Comments for Planning Application DM/2023/01341

Address: 33 Maryport Street Usk Monmouthshire NP15 1AE

Proposal: Demolition of Coach House at rear of No. 31 and Office Building at No. 33 Maryport Street and Construction of a New Dwelling

Commenter Type: Neighbour

Client	MRJT CONSULTANTS LTD.			
Project	NEW DWELLING AT 33 MARYPORT STREET, USK.			
Title	PLAN AND ELEVATION AS PROPOSED	Scale	1:50 @ A1 1:100 @ A3	
Status	PRELIMINARY	Drawn	Date	Approved
		jmt	Nov 2023	---
Job No	2023.347	Dwg. No.	PL03	Rev.
				-

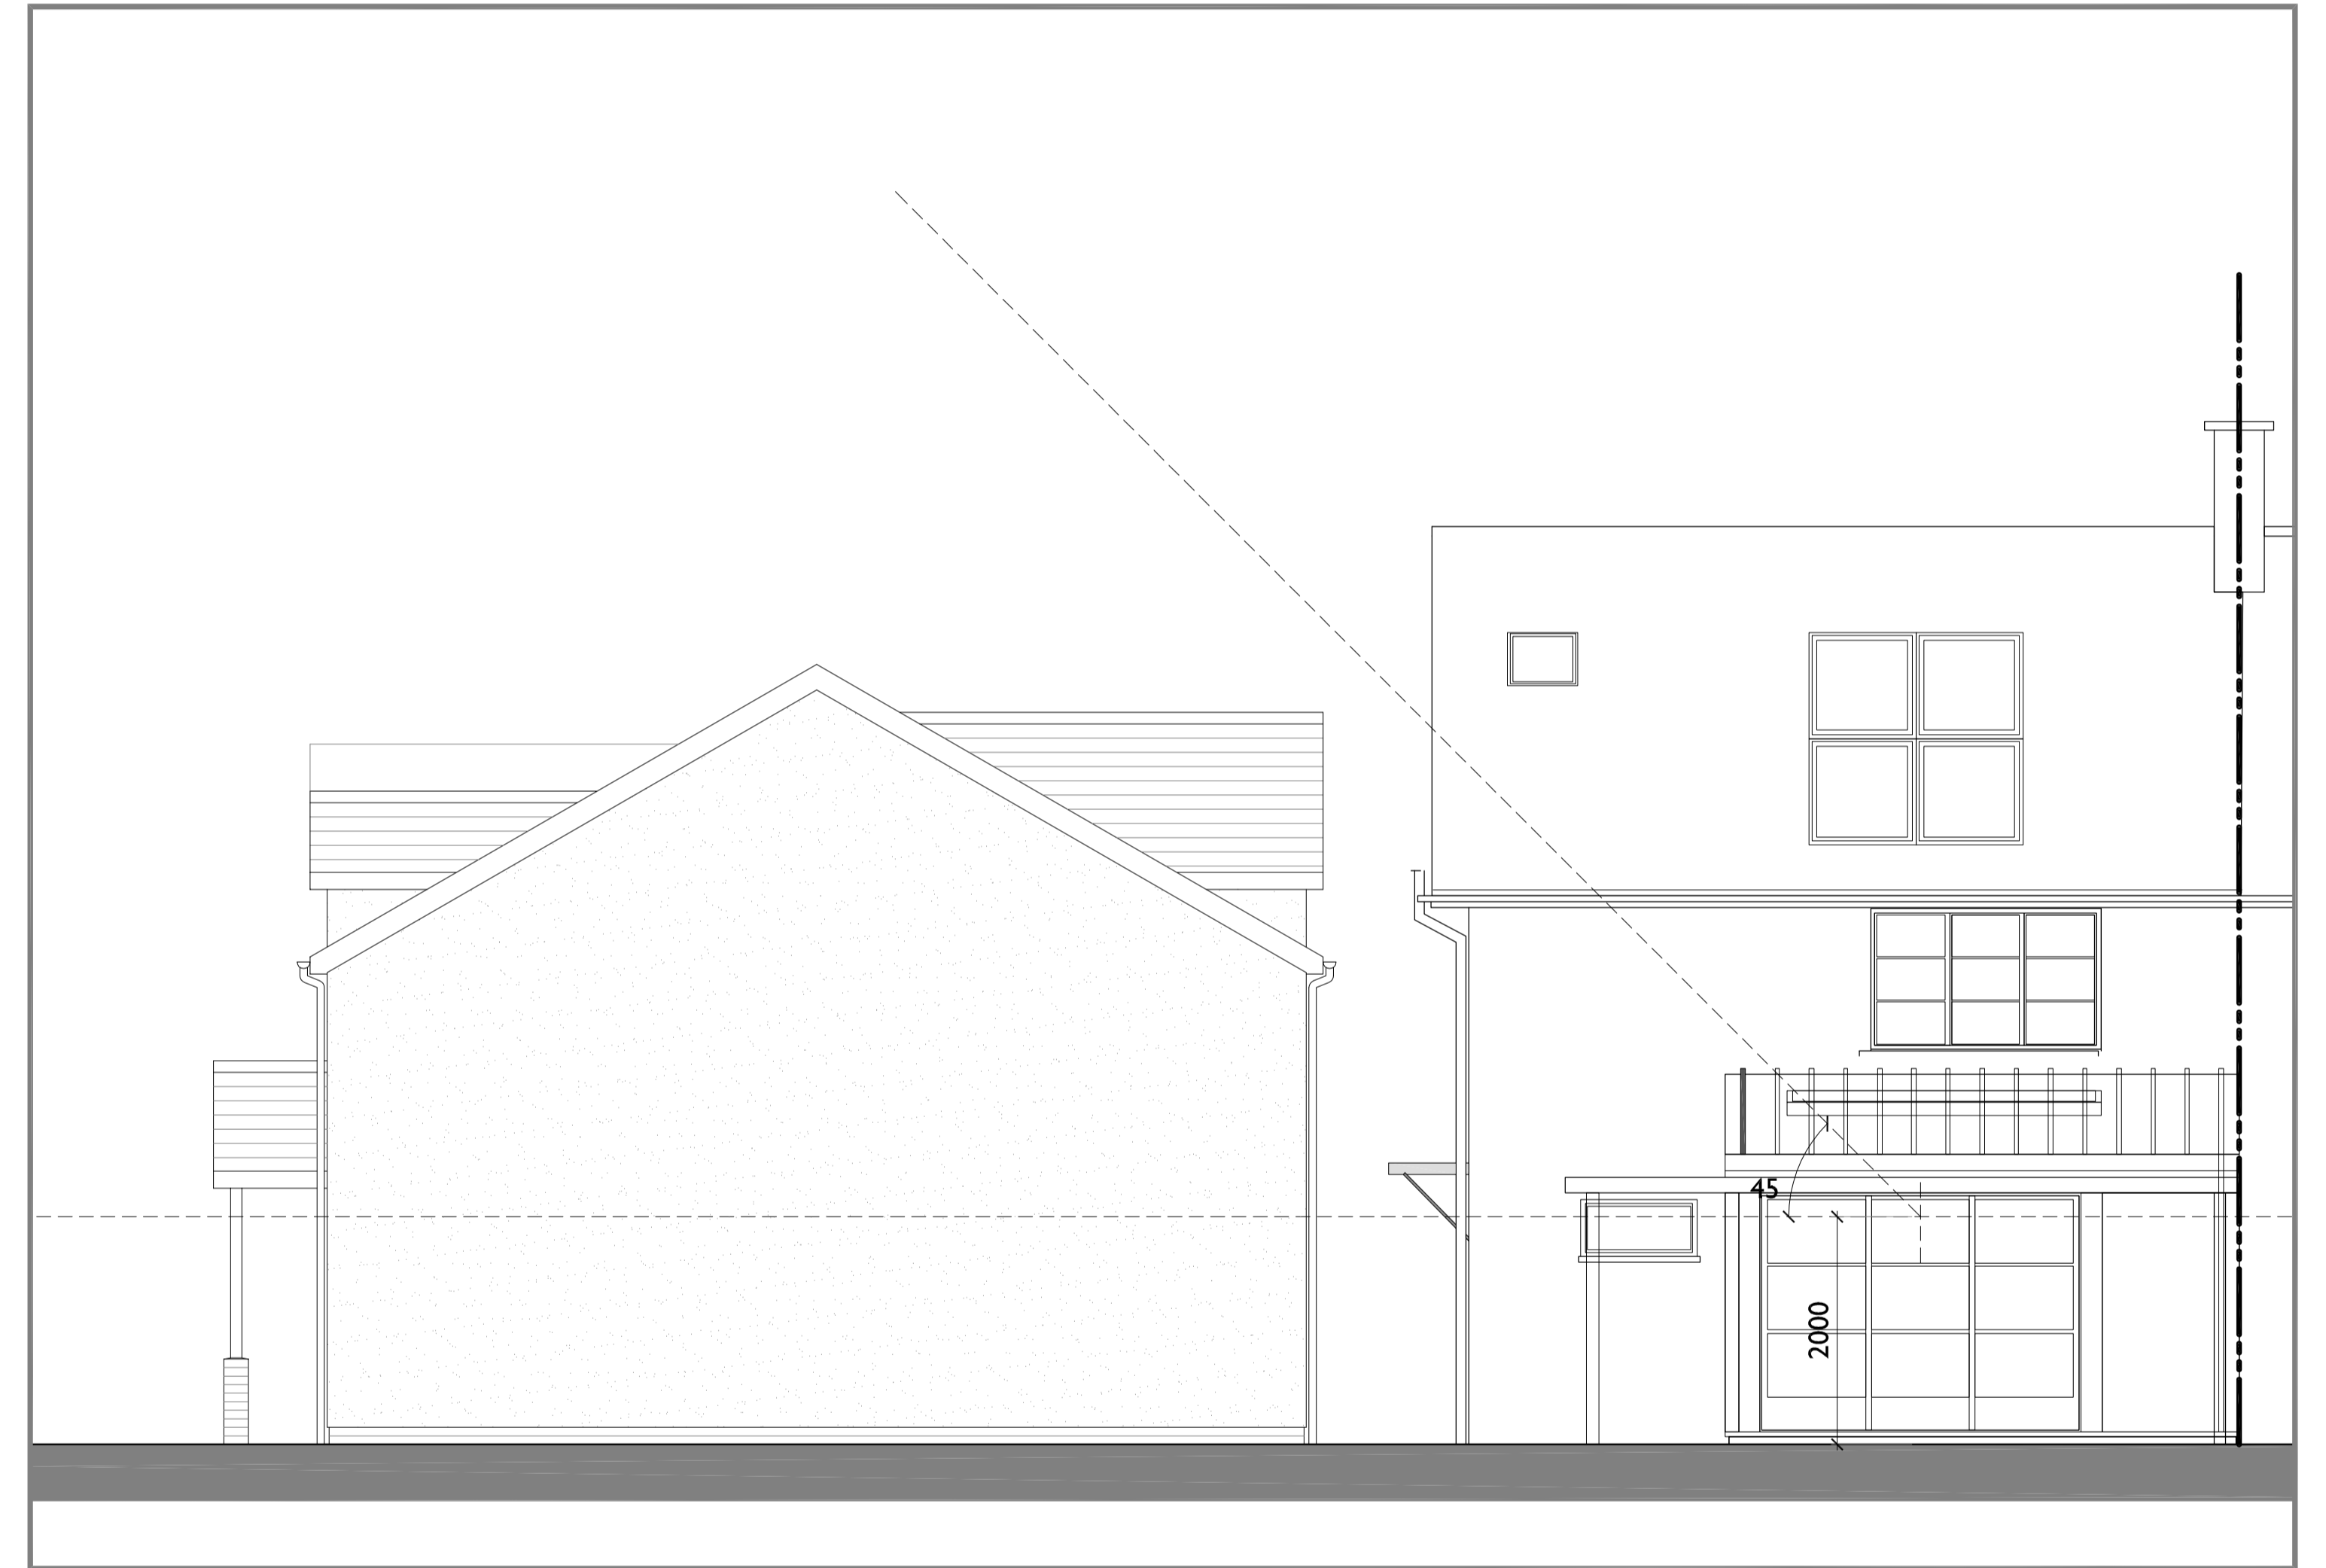
The proposal also breaches the 45 degree rule [REDACTED]

SITE PLAN AS PROPOSED

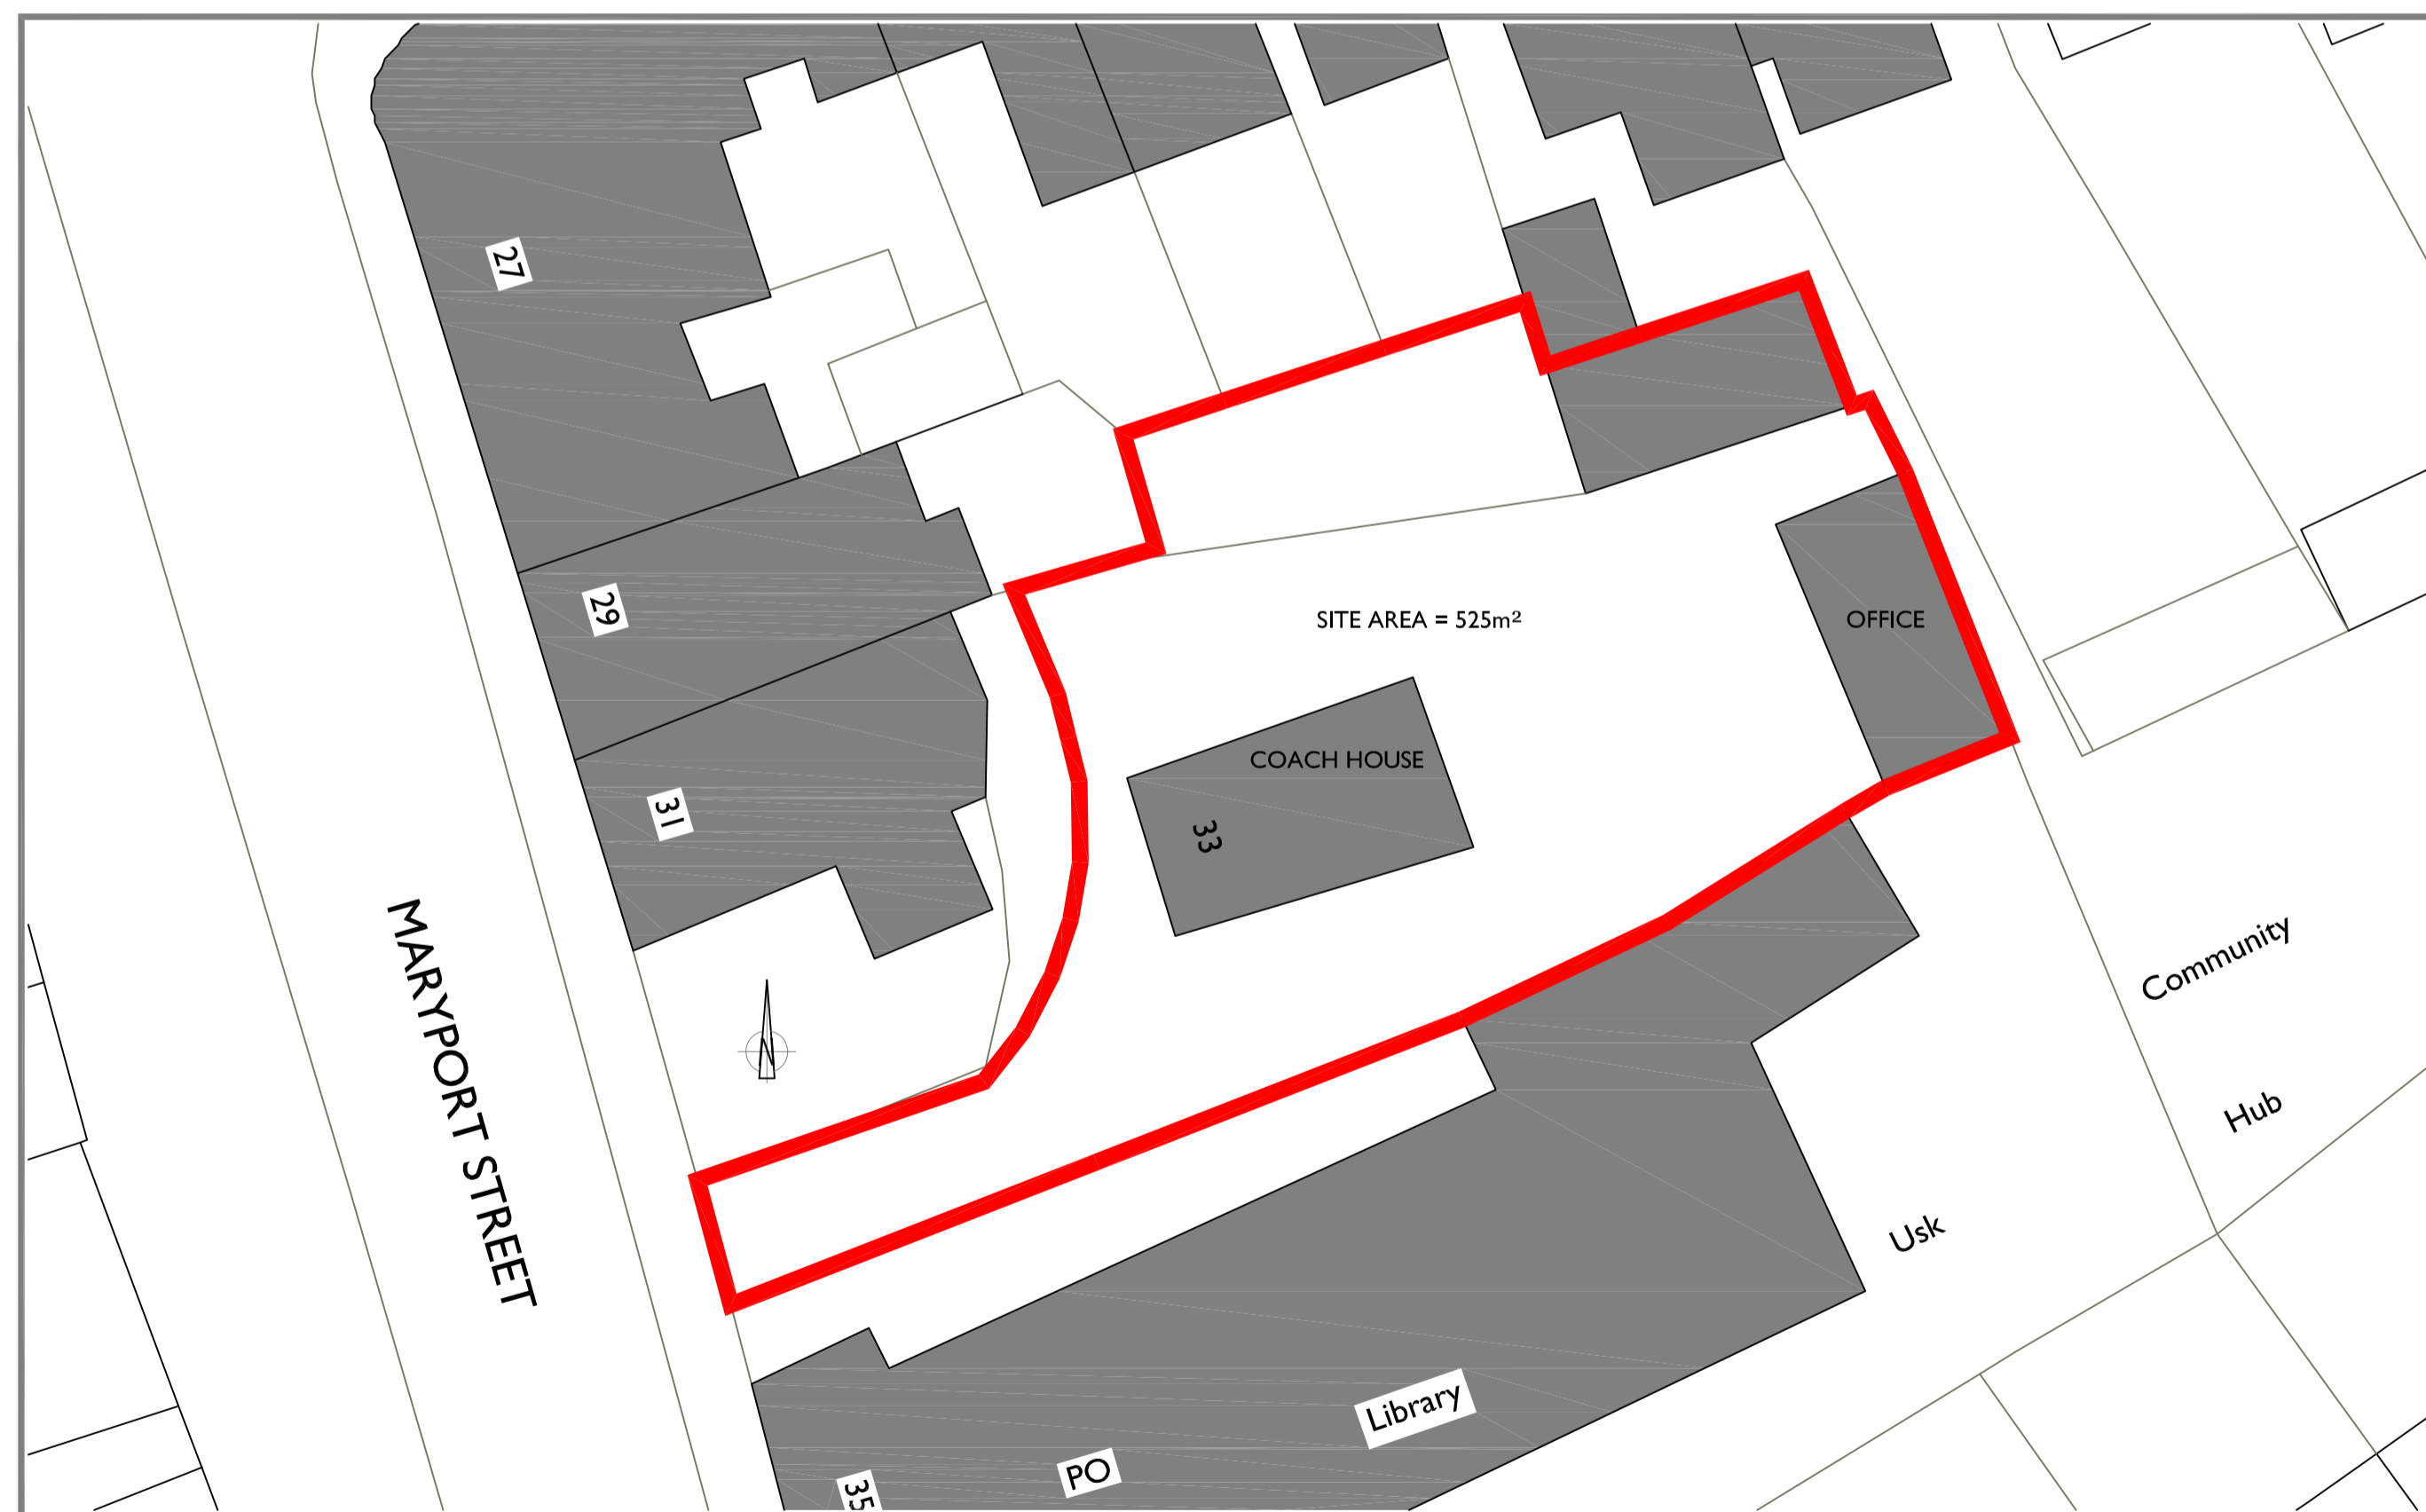
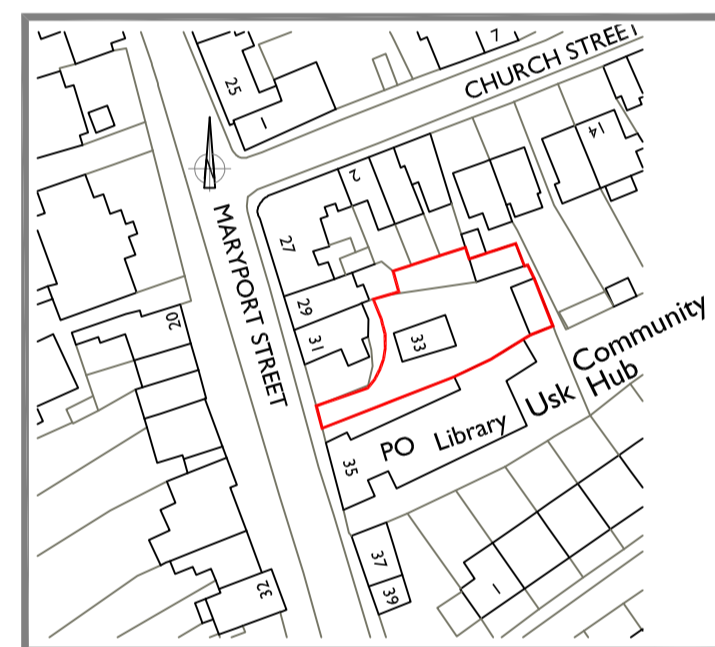
The plan used in the submission is incorrect. [REDACTED]

[REDACTED] It also does not include enough information to clearly demonstrate the distances to [REDACTED]

The new planning application includes an area that [REDACTED] not included in previous applications to develop the site. The buffer area has now disappeared and the proposed house is now circa 6 meters closer [REDACTED]

The previous planning applications for the site included a parking space for the existing property on Maryport Street, this one does not; leading to increased congestion on what is already an area where double parking occurs leading to bottlenecks on a regular occurrence.
